6 October 2022

Re: Advice on Amendment Report - KURRI KURRI LATERAL PIPELINE PROJECT (SSI-22338205)

Fire and Rescue NSW (FRNSW) acknowledge correspondence received on the 4 October 2022, requesting advice on the Amendment Report - KURRI KURRI LATERAL PIPELINE PROJECT (SSI-22338205). FRNSW have reviewed the Submission Report and Amendment Report.

JGN Offtake Facility

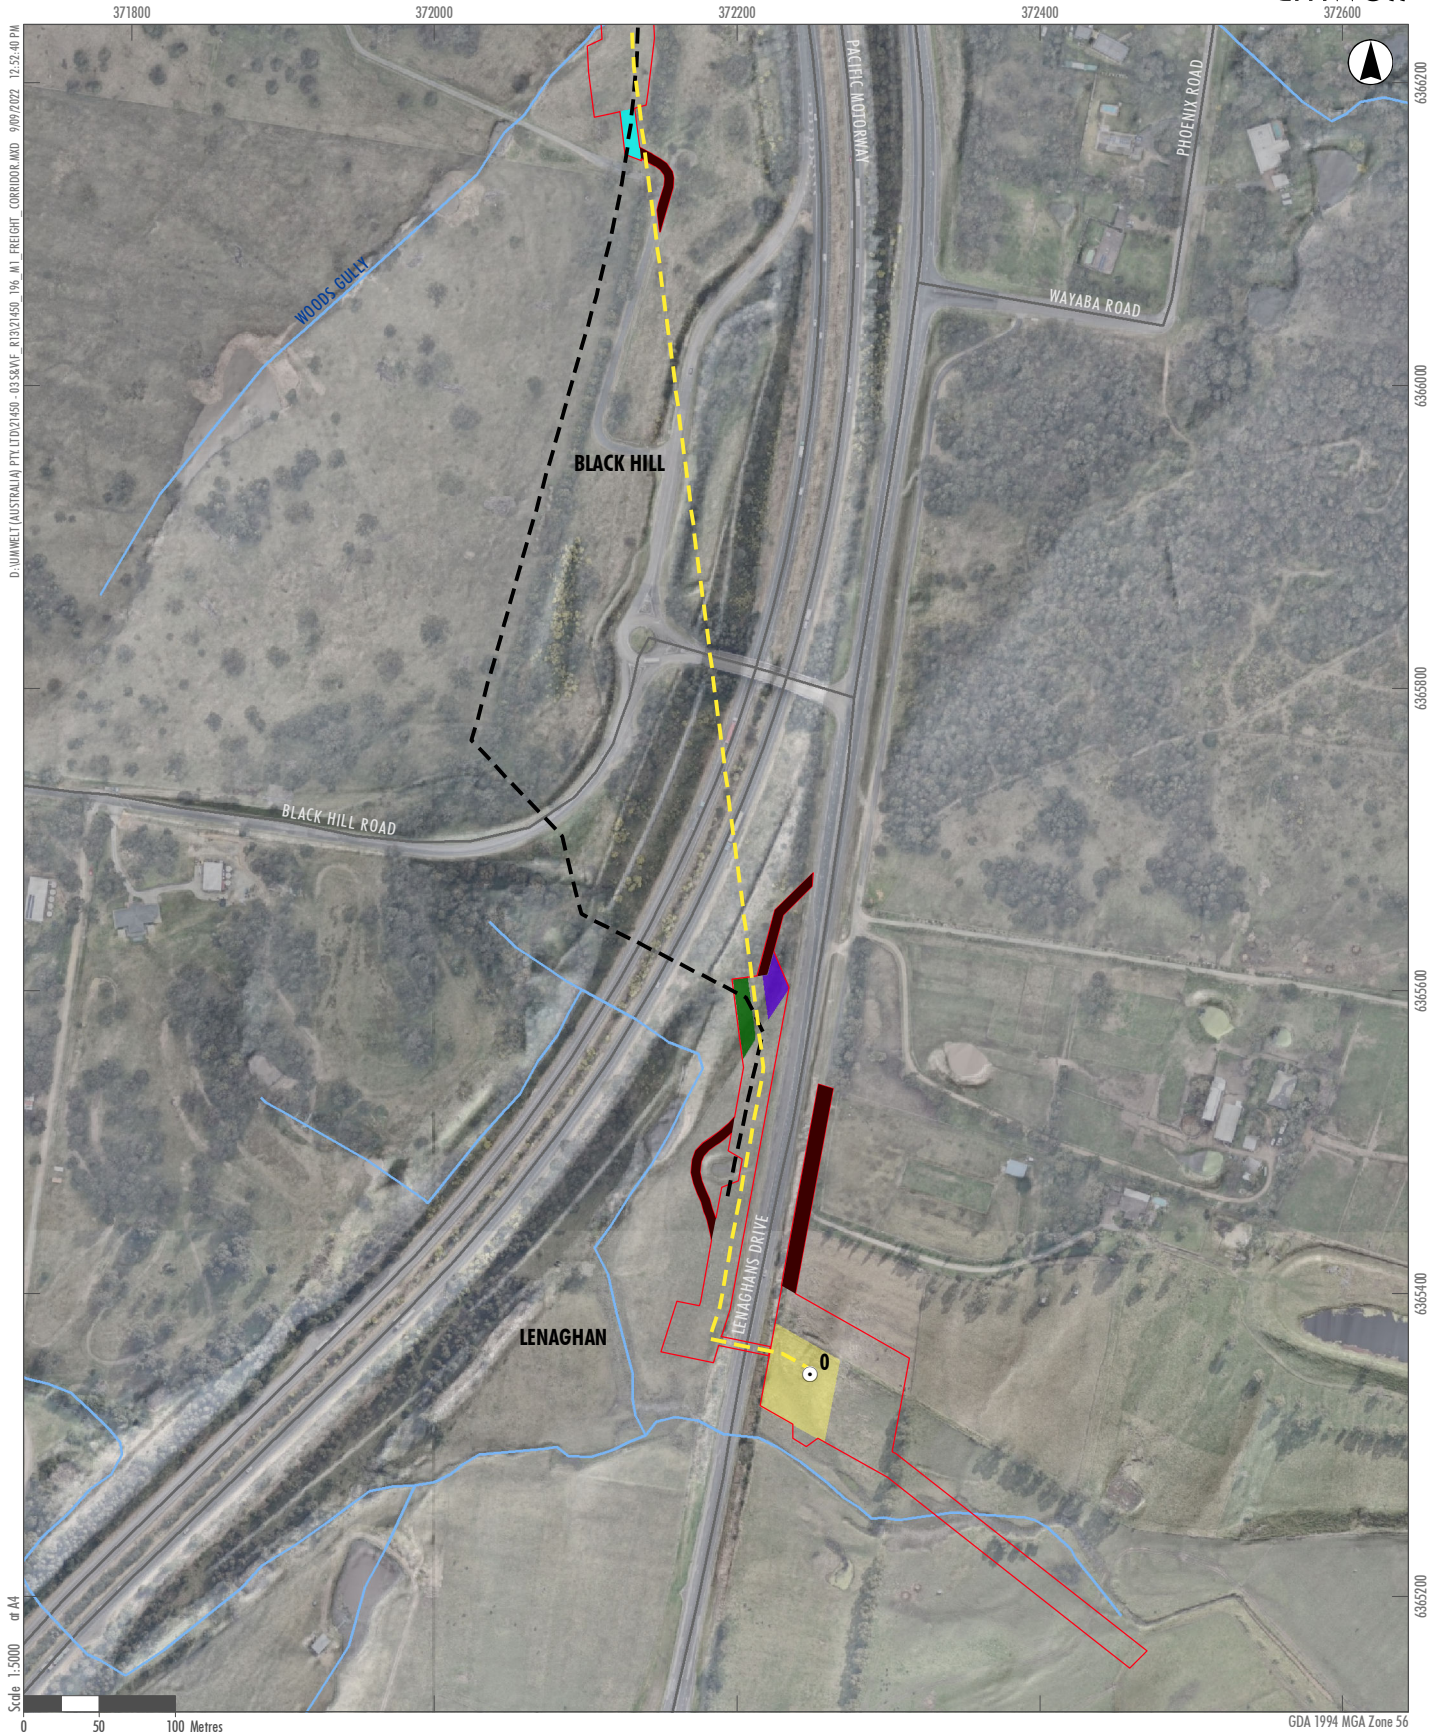
FRNSW note the 'Adequate separation distance' response at 4.6.1 of the Submissions report, given the relocation of the JGN offtake facility, and the response that 'thermal radiation impacts could extend off-site beyond the boundary of the JGN Offtake Facility' FRNSW recommend that:

1. Adequate separation distance be maintained around the JGN Offtake Facility and consideration is given to potential future developments within these distances.
